Randwick City Council
a sense of community

Our Ref: F2011/00512

15 December 2011

MUSIC FESTIVAL, ROYAL RANDWICK RACECOURSE (SSD 4995-2011)

Bump-in Vehicle Management Overview

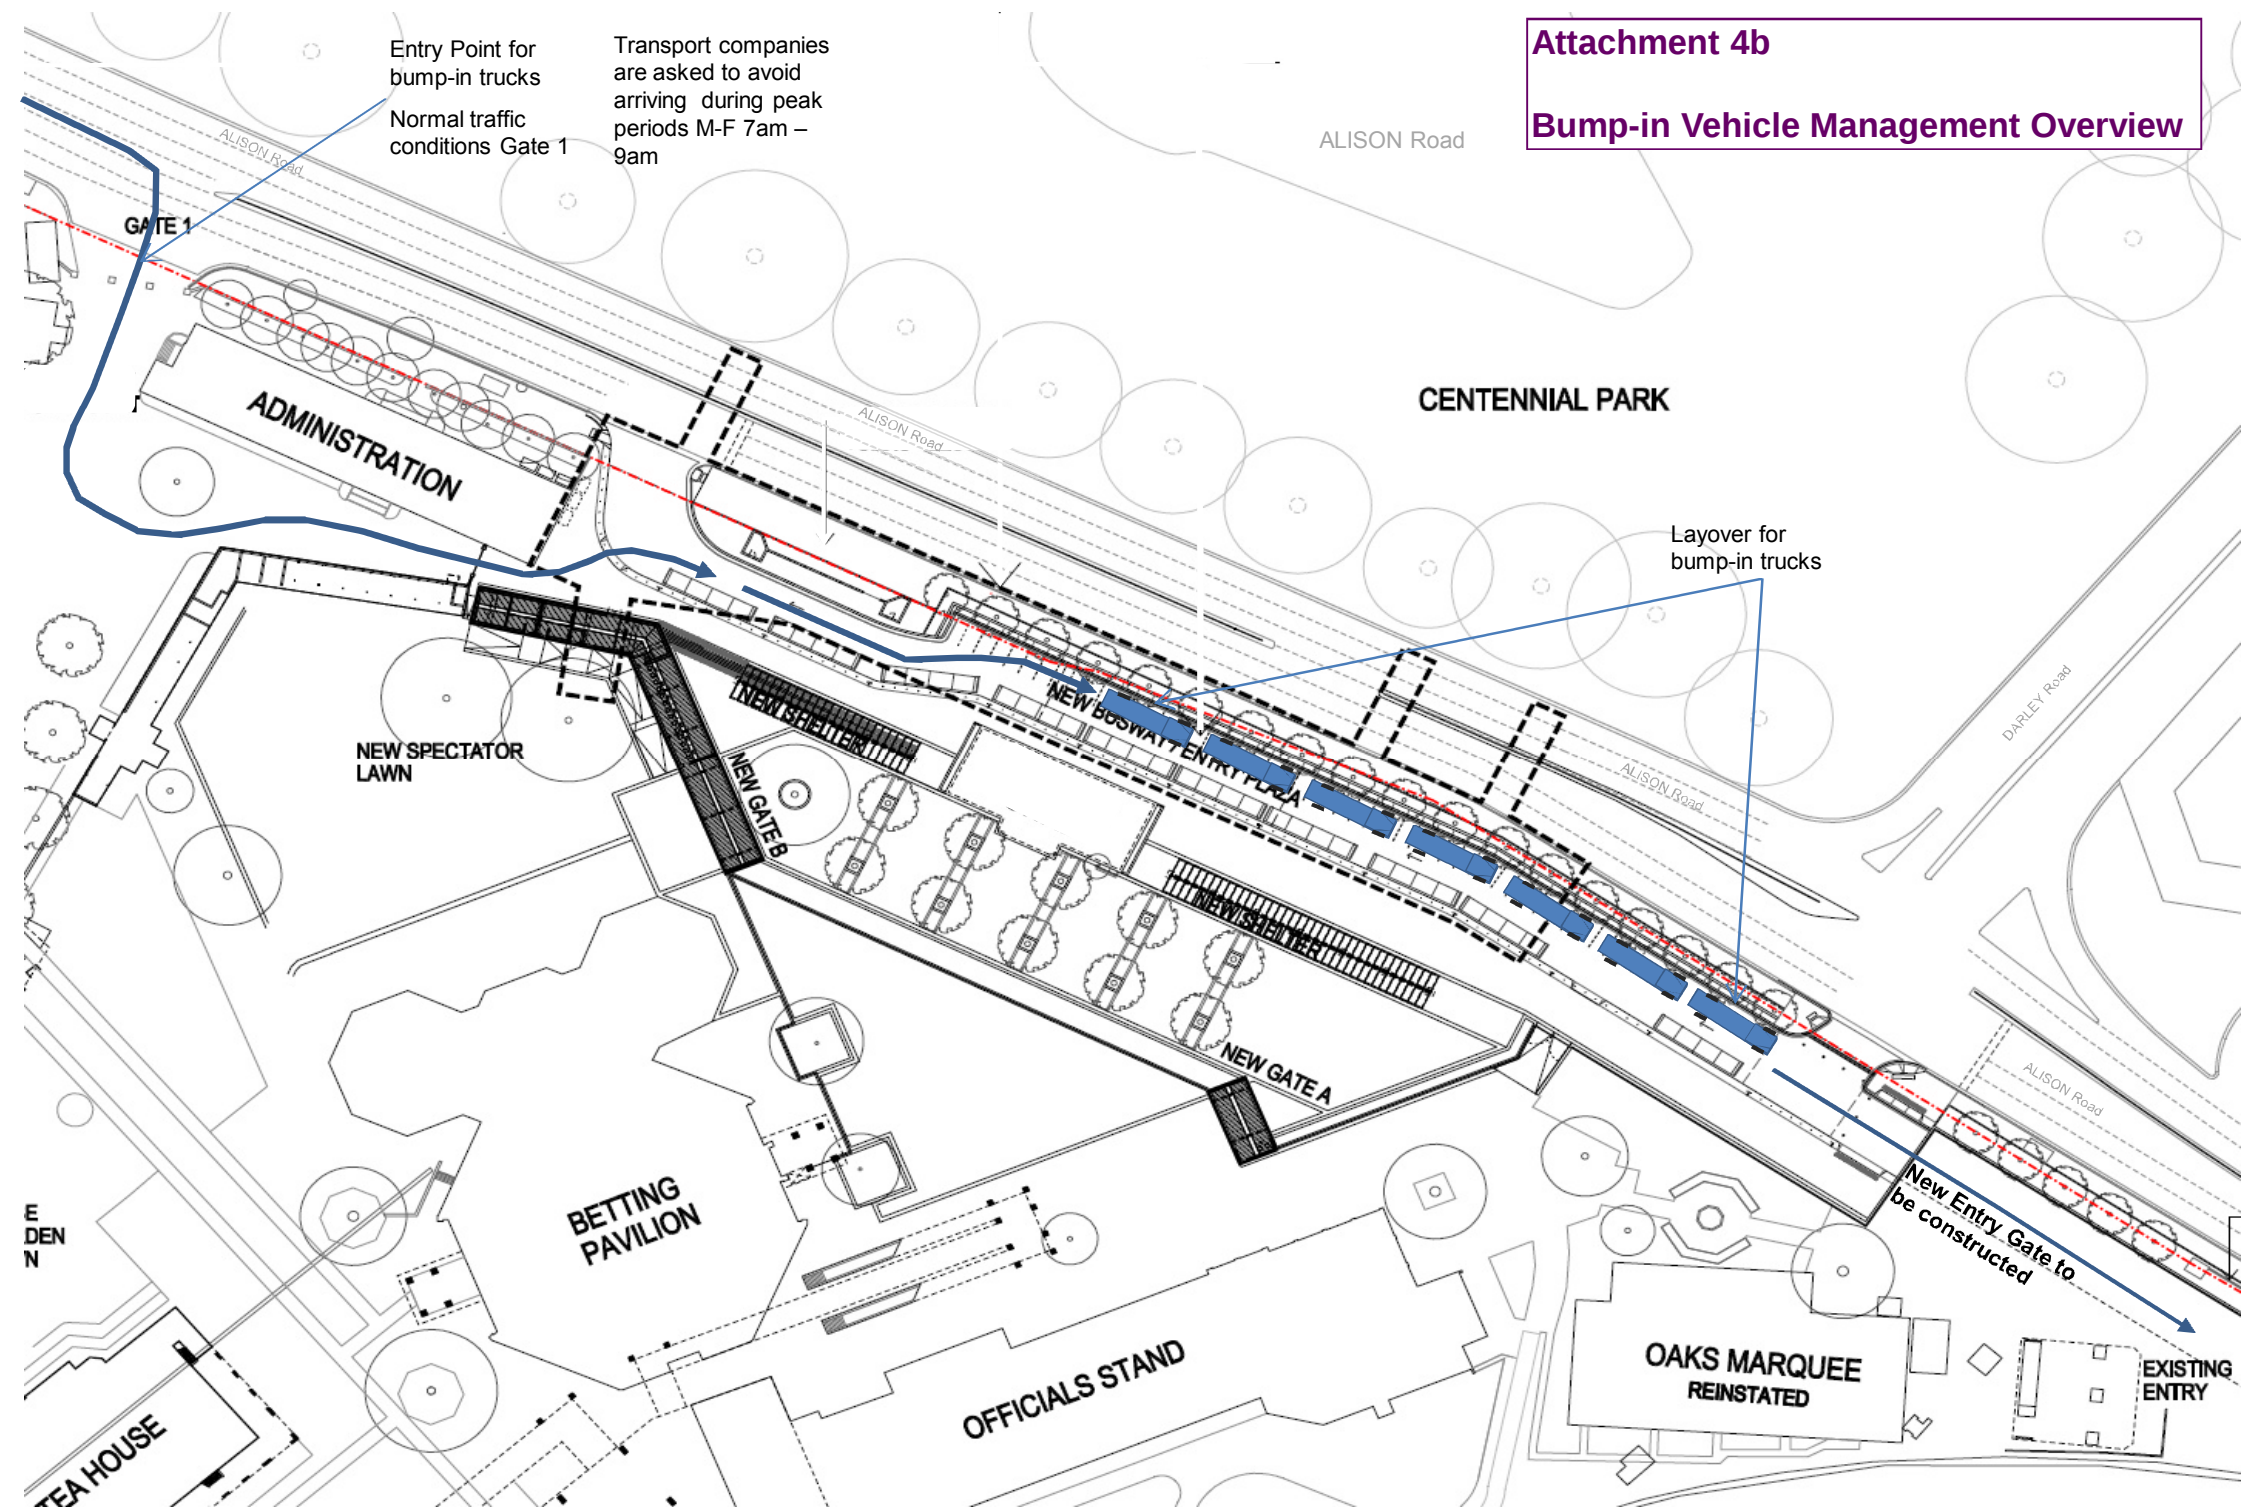
- Strict compliance by truck operators of the "bump in" and "bump out" arrangements on Alison Road and how this is to be enforced.
 - There are no B-double truck approved routes connecting with the racecourse and, as such, no B-double mode of transport shall be used in the project and no B-double mode of transport shall form part of the Traffic Management Plan.

- o Provisions for strict compliance by truck operators of the "bump in" and "bump out" arrangements on Alison Road and enforcement measures.
 - o Clear acknowledgement that no B-double mode of transport shall be used for the event and no B-double mode of transport shall form part of the Traffic Management Plan.

2012 Future Music Festival**TCP No. 8a****Wansey Rd / Infield Road to Event Parking Randwick (Gate 10)****Ingress****Ingress: 11:30am – 5:00pm****Peak: 12:30am – 2:30pm****Staff From 6am**

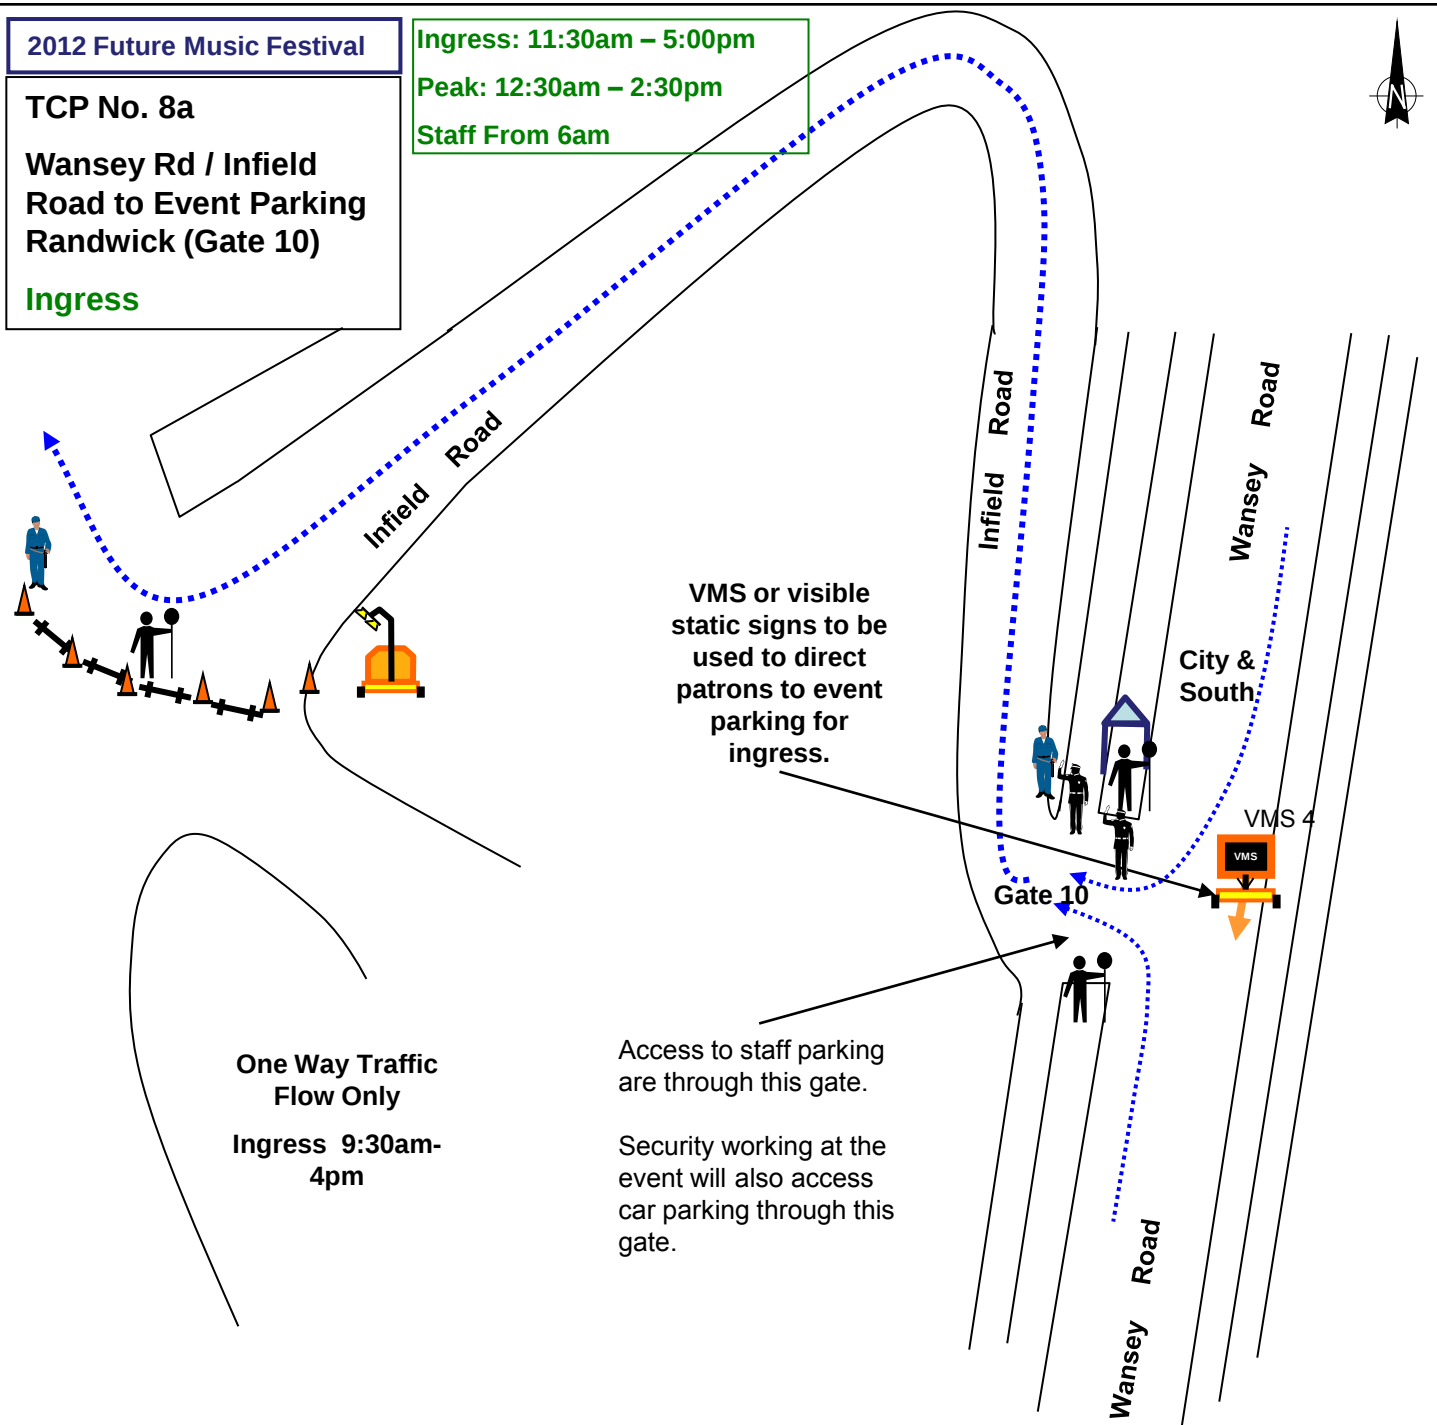
- The TMP still refers to Wansey Road as a thoroughfare for operational traffic. Council would emphasise that no operational traffic for the event shall use Wansey Road.
